Application No. **H16/0269/96**

**18M SERVICE STRIP INCORPORATED TO
PROVISING CLOSE SERVING PLOTS
17-19, 21-23.**

**ROAD ALSO RE-ALIGNED SERVING
ABOVE PLOTS AS REQUESTED BY
LCC HIGHWAYS.**

**Re: Proposed Residential Development Off Wygate Park, Spalding, Lincolnshire
Planning Ref : H16/0269/96**

Project title
**Proposed Residential Development
Wygate Park,
Spalding,
Lincolnshire.**
Phase 2 & 3 Plots 1-34
drawing
Site Layout

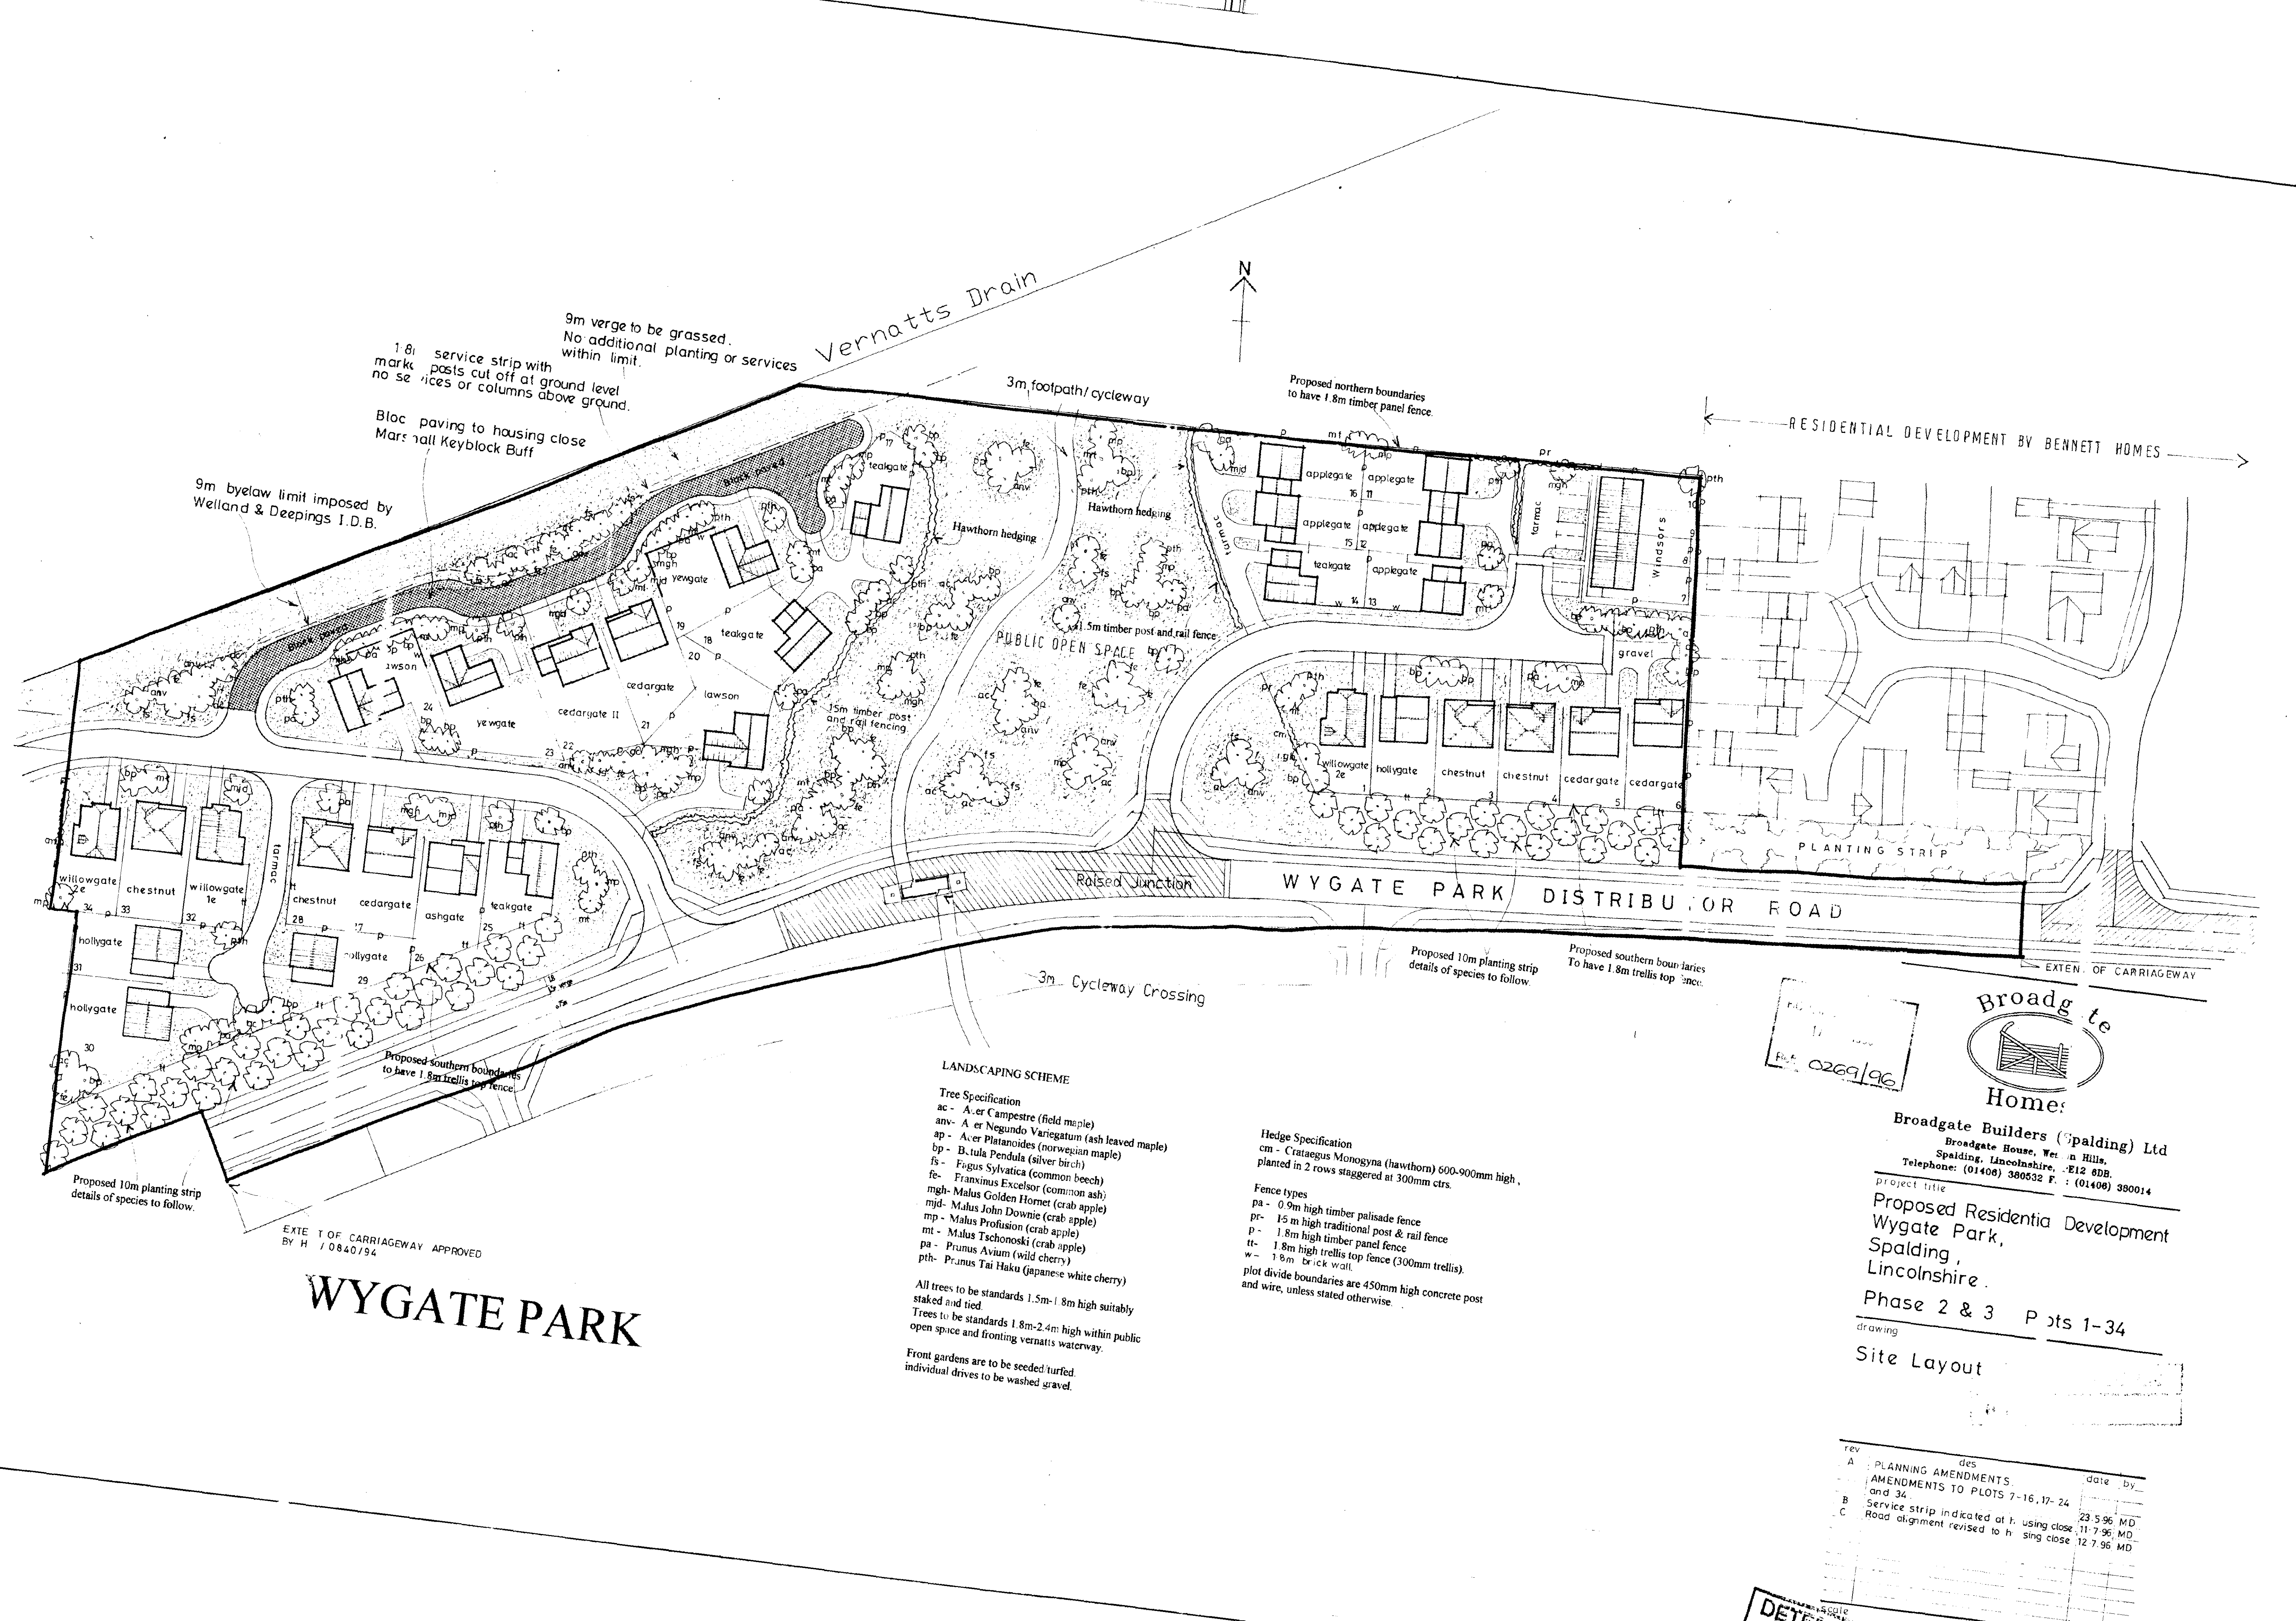
- 1-Housing close re-positioned and re-aligned not to fall within the 9m easement strip, as requested By the Welland And Deepings Internal Drainage Board.
No other construction, services or Tree and shrub planting can be proposed within that area.

- 2-Plots 11-24 re-positioned.
- 3-House design substitutions to plots 17-24, incorporating double fronting house types overlooking The public open space and Vernatts waterway.

- 4-Public open space re-aligned giving a more pleasing approach leading to the development and To the vernatts waterway.
- 5-Estate road adj. To plot 34 re-aligned so the position of the road does not fall within the easement strip. Plot 34 repositioned to suit.

- 6-Staggered cycleway crossing indicated on layout with the re-alignment of the 3m cycleway to the Northern boundary.
- 7-Private drive serving plots 14-16 increased in width to 4.2m. And to have a finished surface of Tarmac and not gravel as previously proposed.

- 8-Parking court re-designed serving plots 7-11.
- 9-Gravel drive re-positioned serving plots 11-13.
- 10-Block pavours proposed for the housing close serving plots 17-19 and 21-23.

- 11-Removal of toddlers play area from public open space, as discussed.
